J.S. THOMPSON
ENGINEERING, INC

August 22, 2024

Re: Plans engineered by J.S. Thompson Engineering, Inc.

The plans under construction in the Tobacco Road subdivision in Angier, North Carolina were reviewed to address the required connection at the top of the front porch posts.

S-31
SECOND FLOOR
FRAMING PLAN

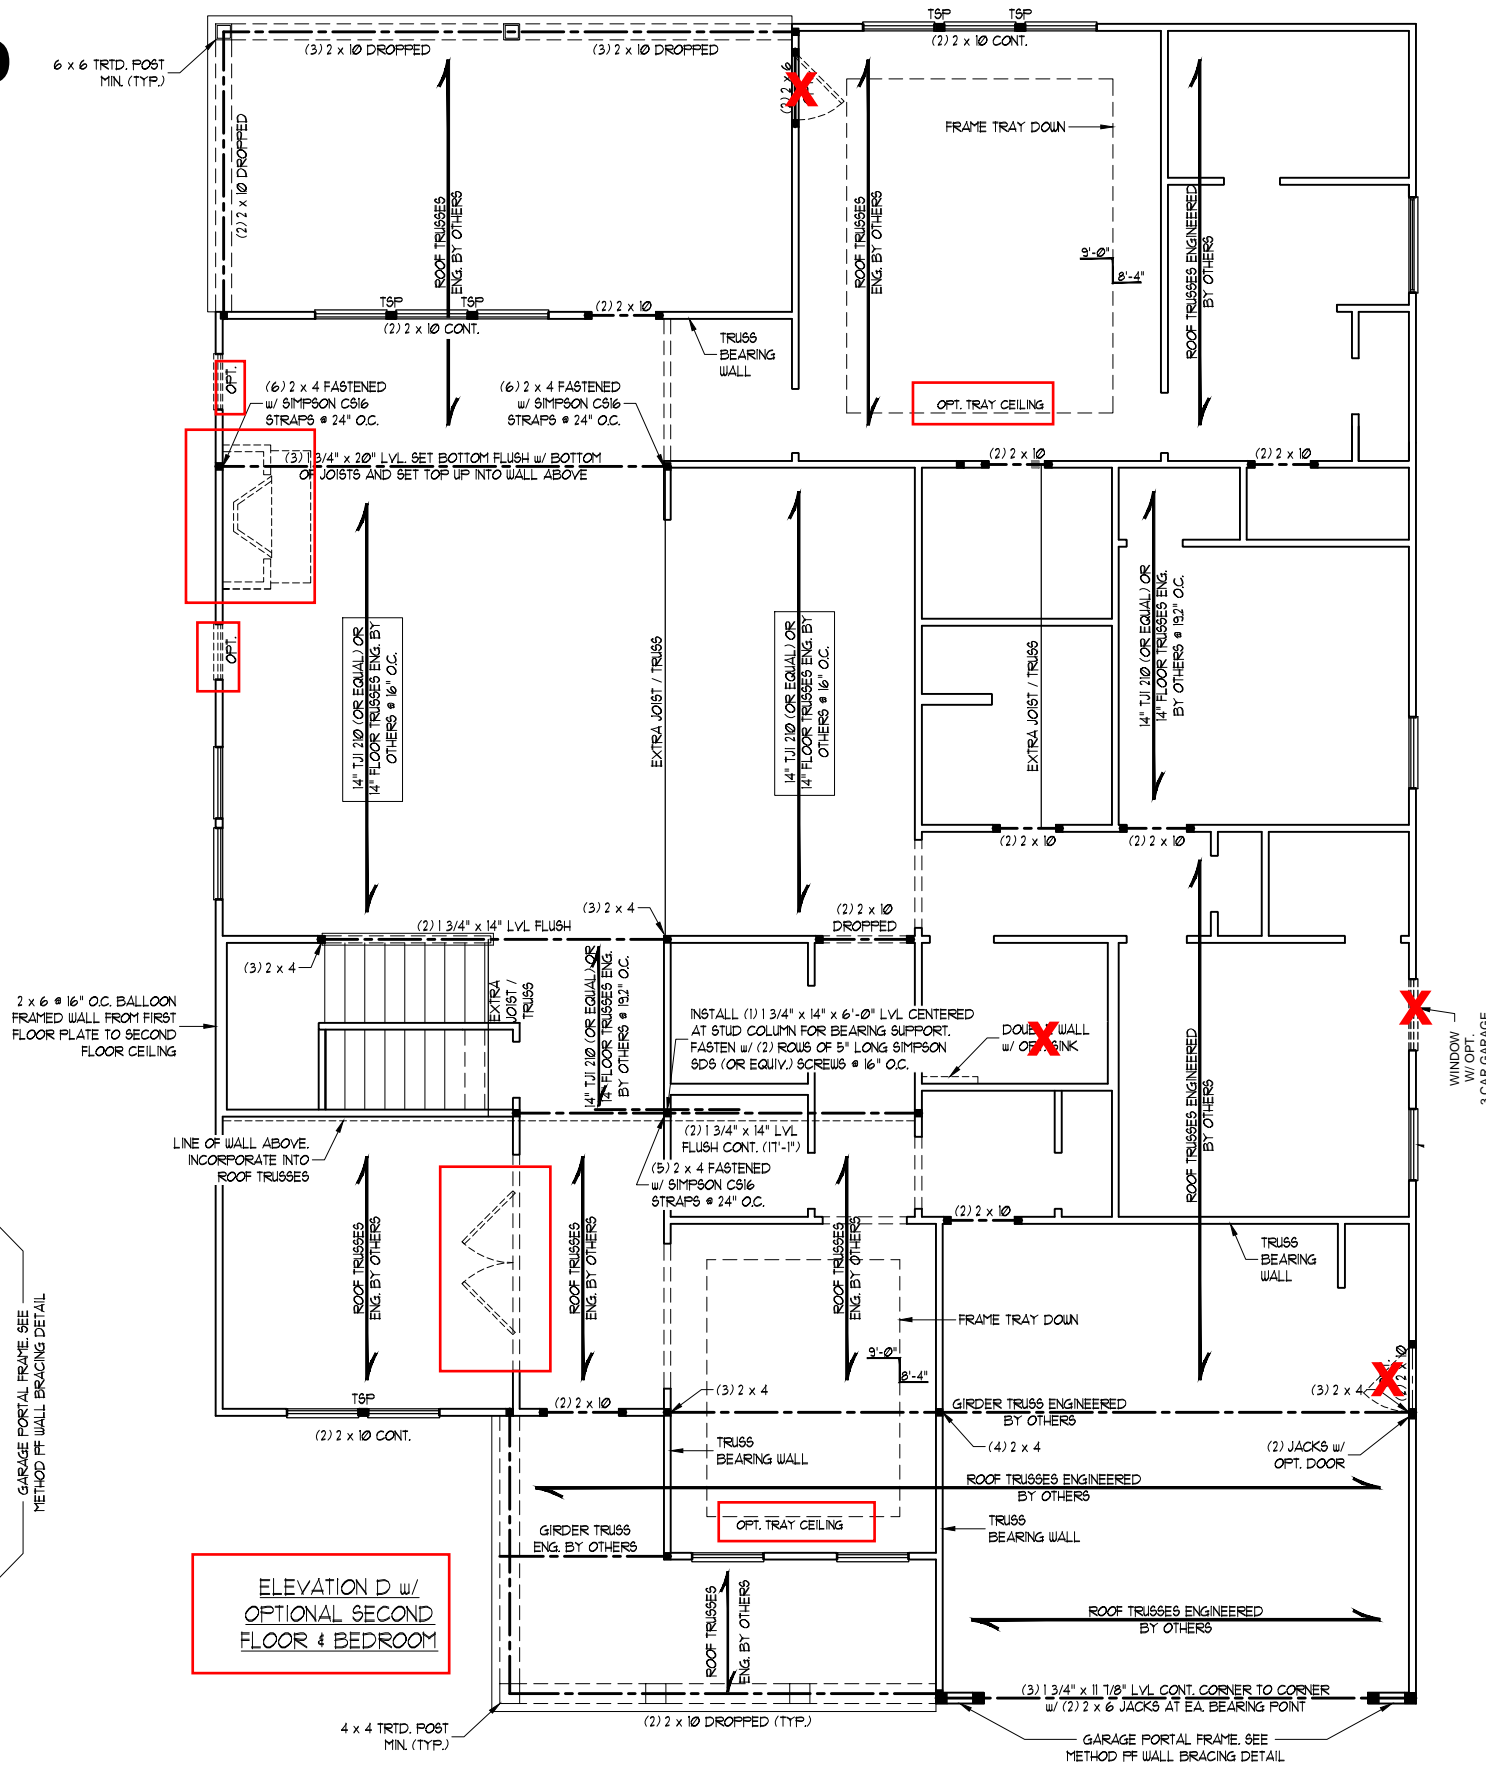
Unless specific hardware is designated at the porch framing, the top of the 4 x 4 or 6 x 6 treated posts are to be secured with Simpson CS16 strapping with 9" end lengths. Strapping is to be installed per the manufacturers specifications to extend fully onto the face of the beam and downward onto the post. The strapping will satisfy the 700-pound uplift requirement specified in the structural notes on the second-floor framing page. This configuration will provide the required support for all applied loads.
